Application Reference: 2026/0448

Site Address: 15 Wentworth Crescent, Penistone, Sheffield, S36 6ES

Introduction: This application seeks full planning permission for the removal of detached garage to side and erection of single storey rear extension, rear dormer and infill to front recess to dwelling.

Client	Martin and Vicky	Issued From	
Project	2657 : 15 Wentworth Crescent : Domestic Extension	Date	May 2026
Title	Proposed Ground and First Floor Plans	Scale	1:50 @ A1
Drawn	BH	Auth	BH

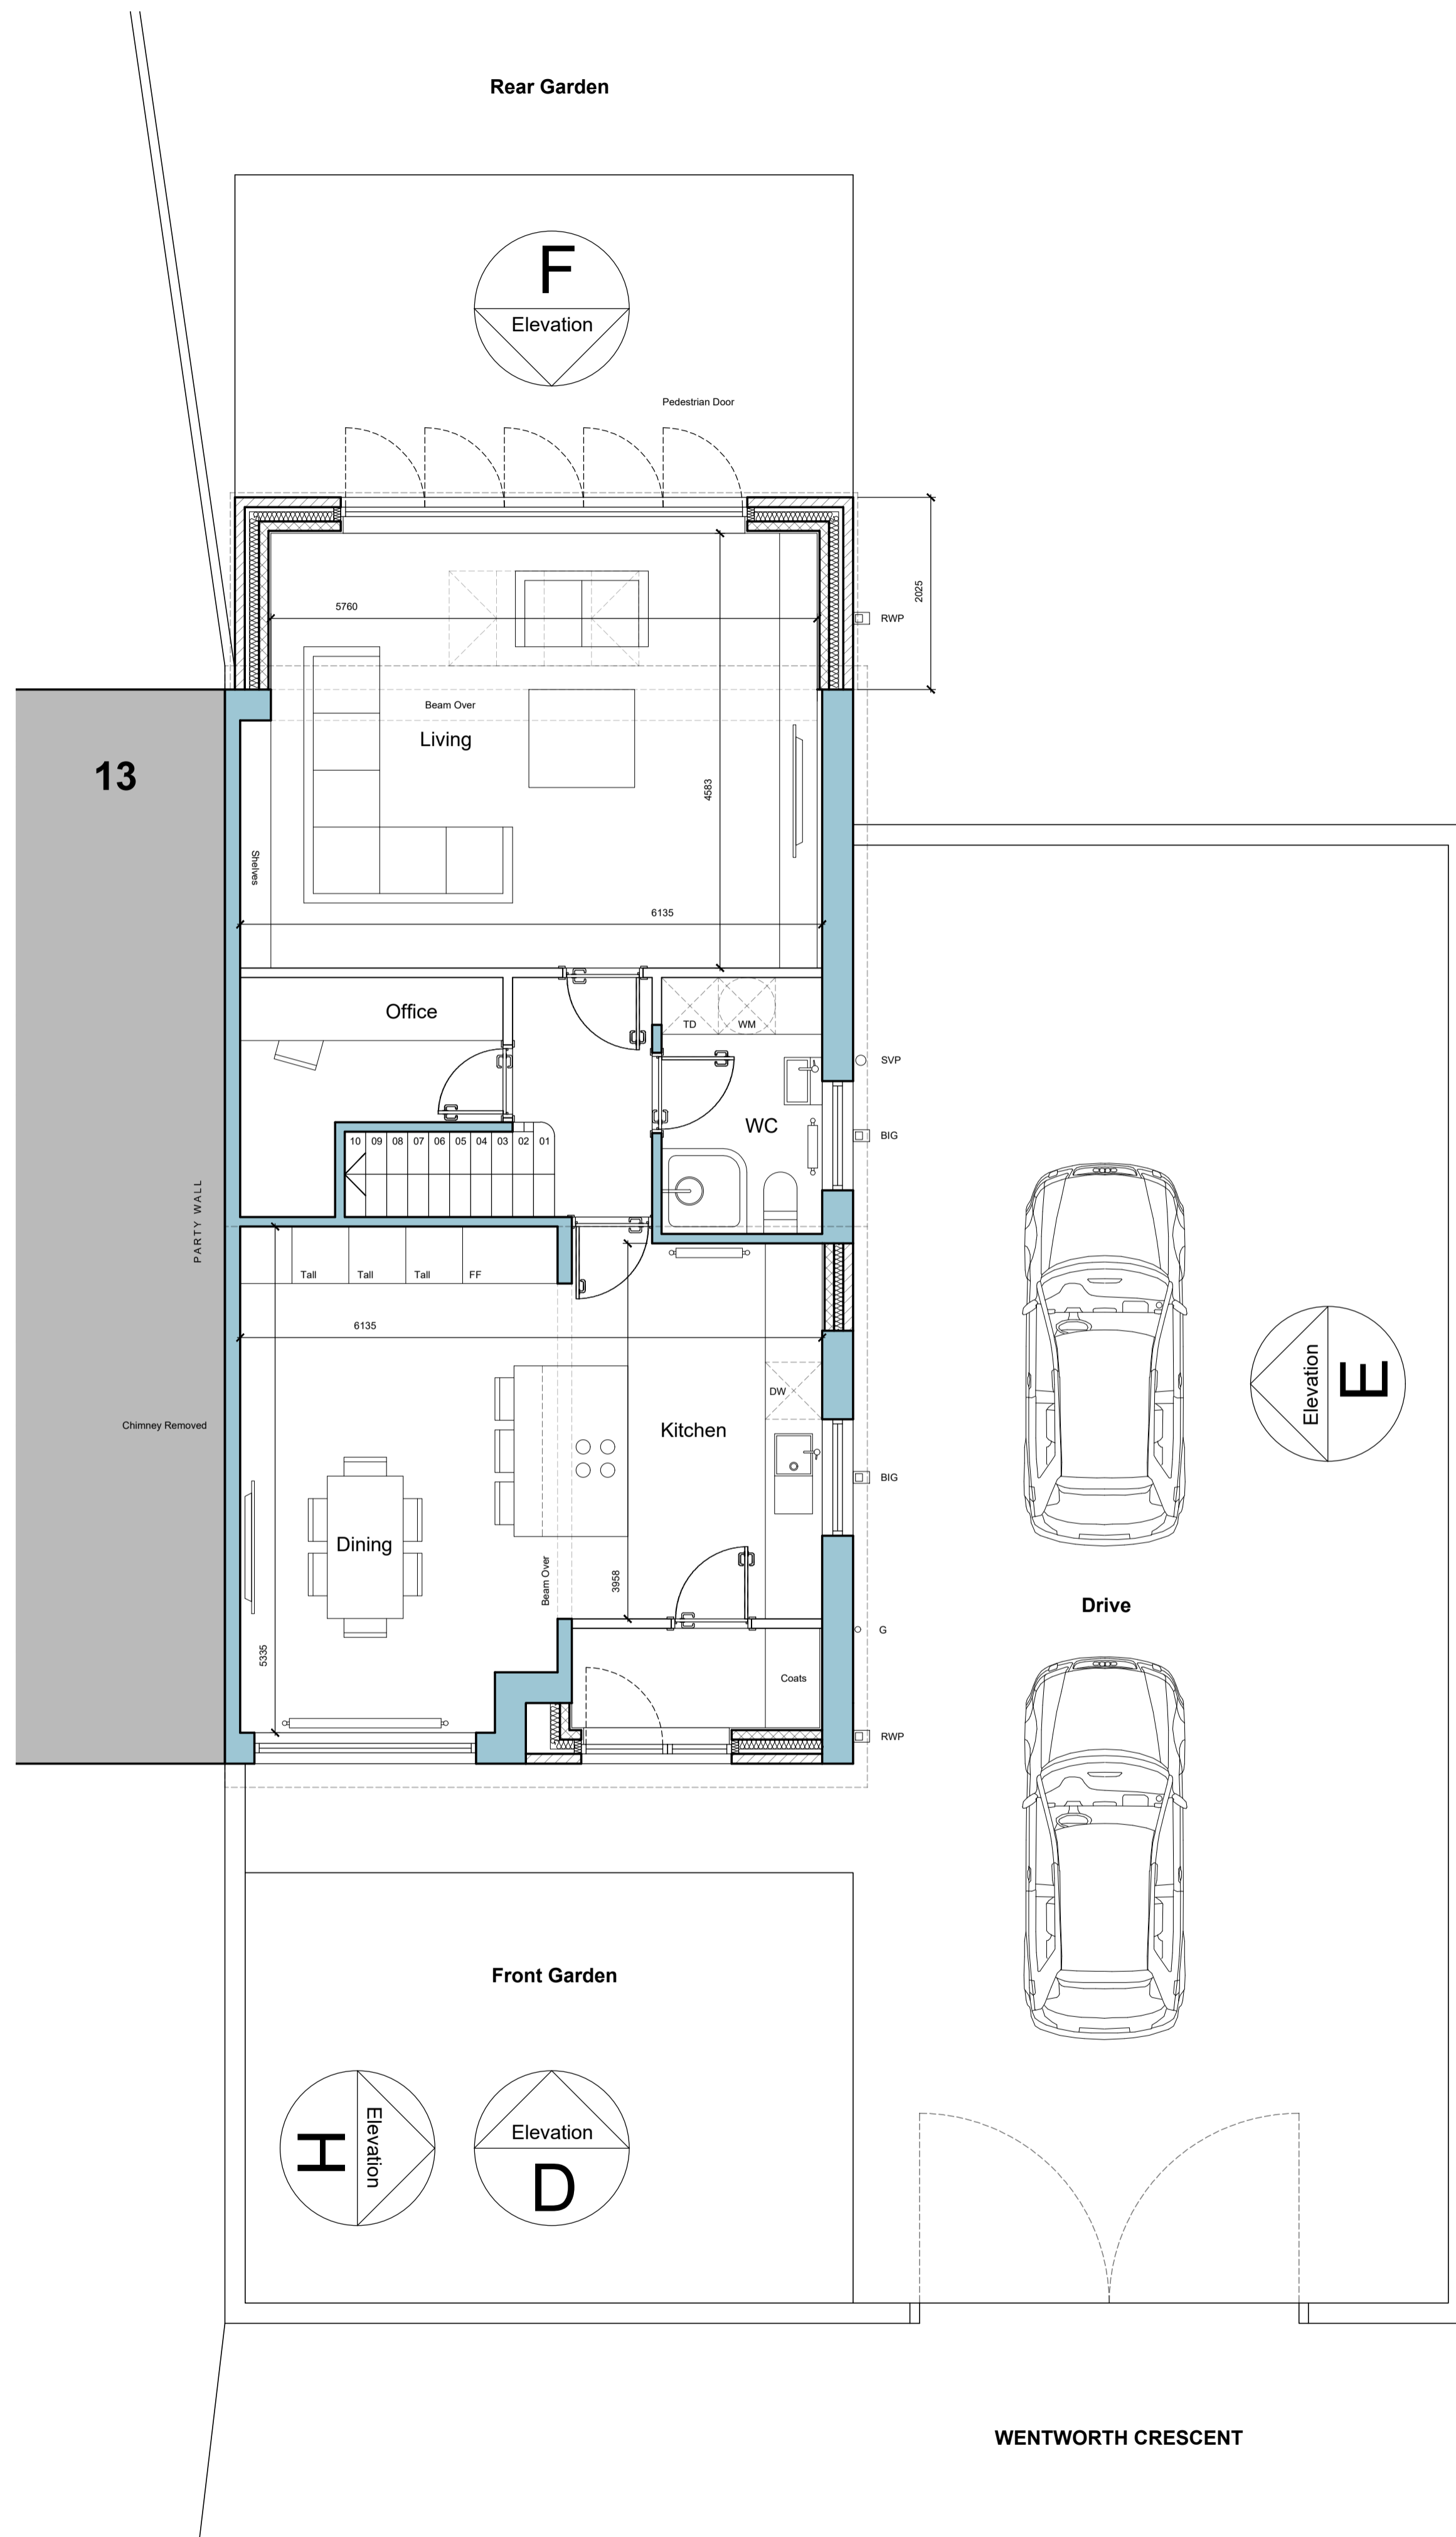
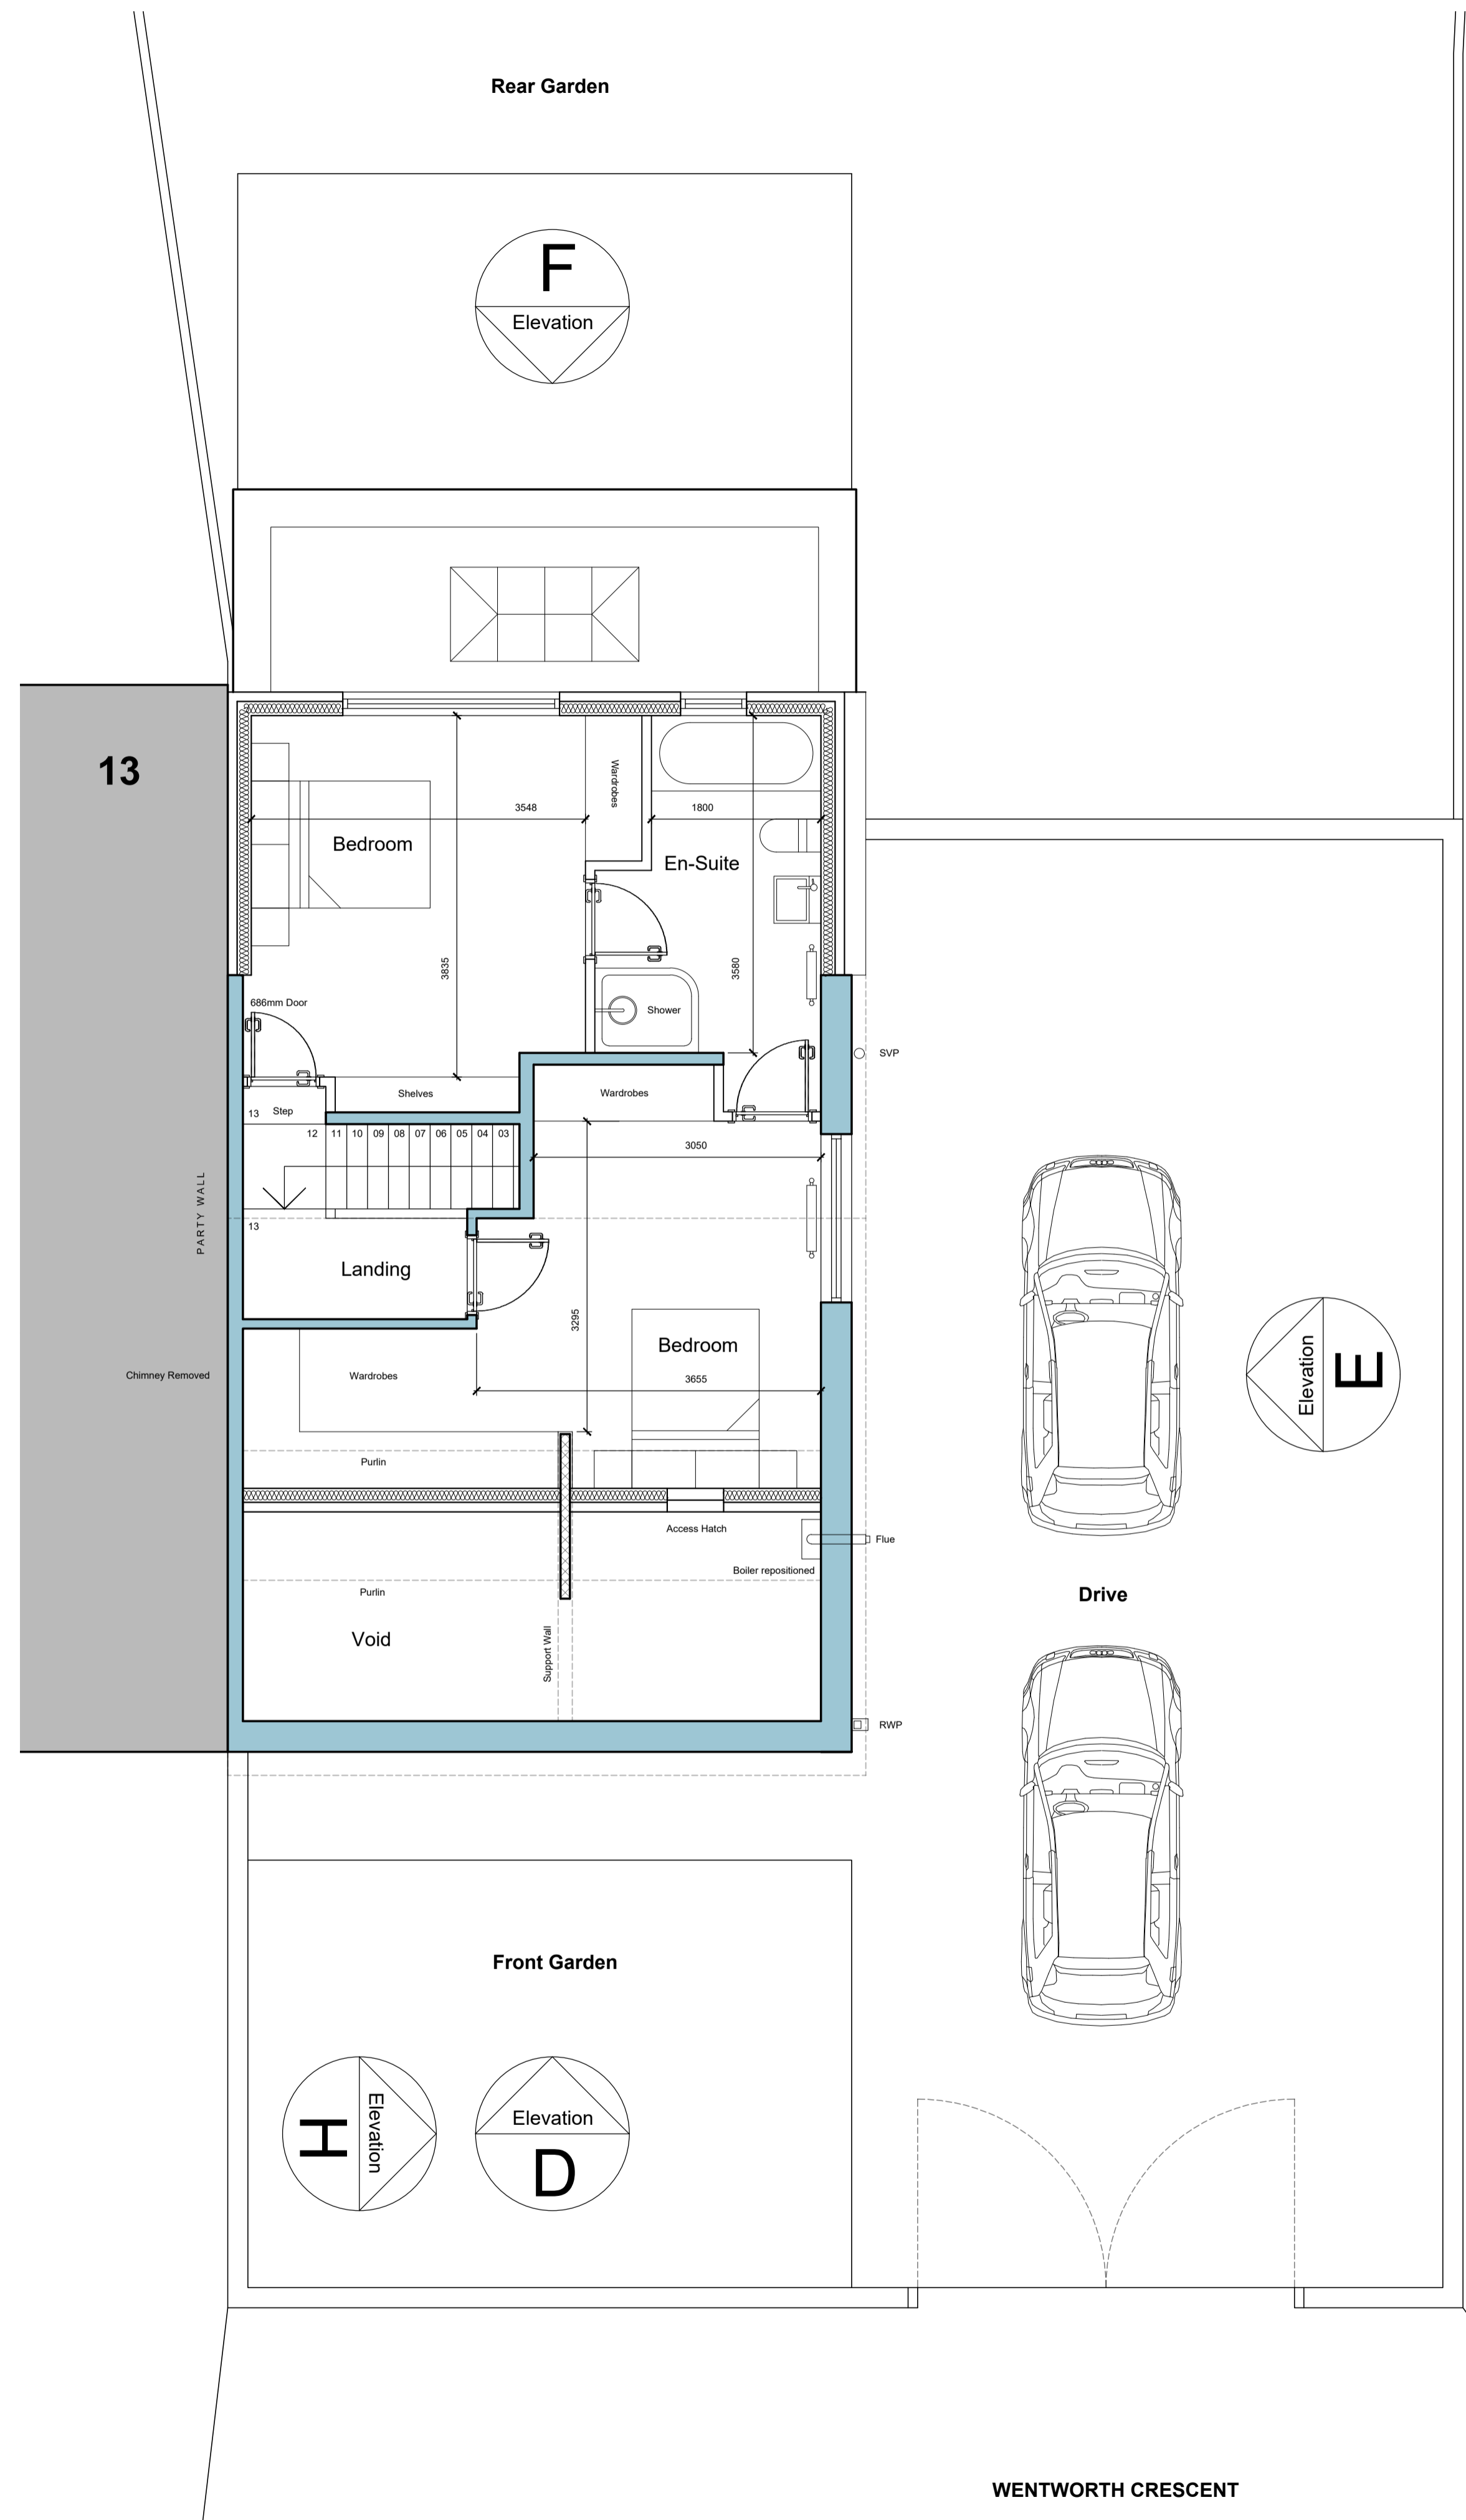
The approximate 2.3m rear projection of the proposed ground floor rear extension, which also practically extends across the whole width of the rear elevation, is less than the 3m usually allowed through permitted development. However, with an approximate flat roof height of 3.10m, which is also higher than the existing eaves height of approximately 2.64m, and with a roof lantern extending to about 3.38m, the proposal does not meet the height requirements for permitted development, with this type of roof. For a planning application, whilst the eaves should not usually be higher than the existing eaves, the main roof is also being altered, but not heightened, and it is the rear elevation, not the principal front elevation, so would not be as impactful within the street scene as if it was constructed on the front elevation.

The proposed infill within the front elevation of the dwelling, along with relocation of the principal entrance door onto the front elevation would potentially provide the most significant change to the design and character of the dwelling. If the front door had already existed on the front elevation, then the infill, at less than 3 sqm, may have qualified as permitted development. Whilst the proposal does potentially improve the design of the application dwelling, the counter effect of unbalancing the symmetry of the pair of semi-detached bungalows and the combined trio of similarly designed pairs of bungalows on the street must be considered.

The front infill extension would not notably impact the amenity of No 13, but it would relocate the principal entrance door of the application dwelling to within 4m of the boundary treatment between the dwellings, so there is the potential for a limited impact of additional noise arising from use of the relocated entrance door.
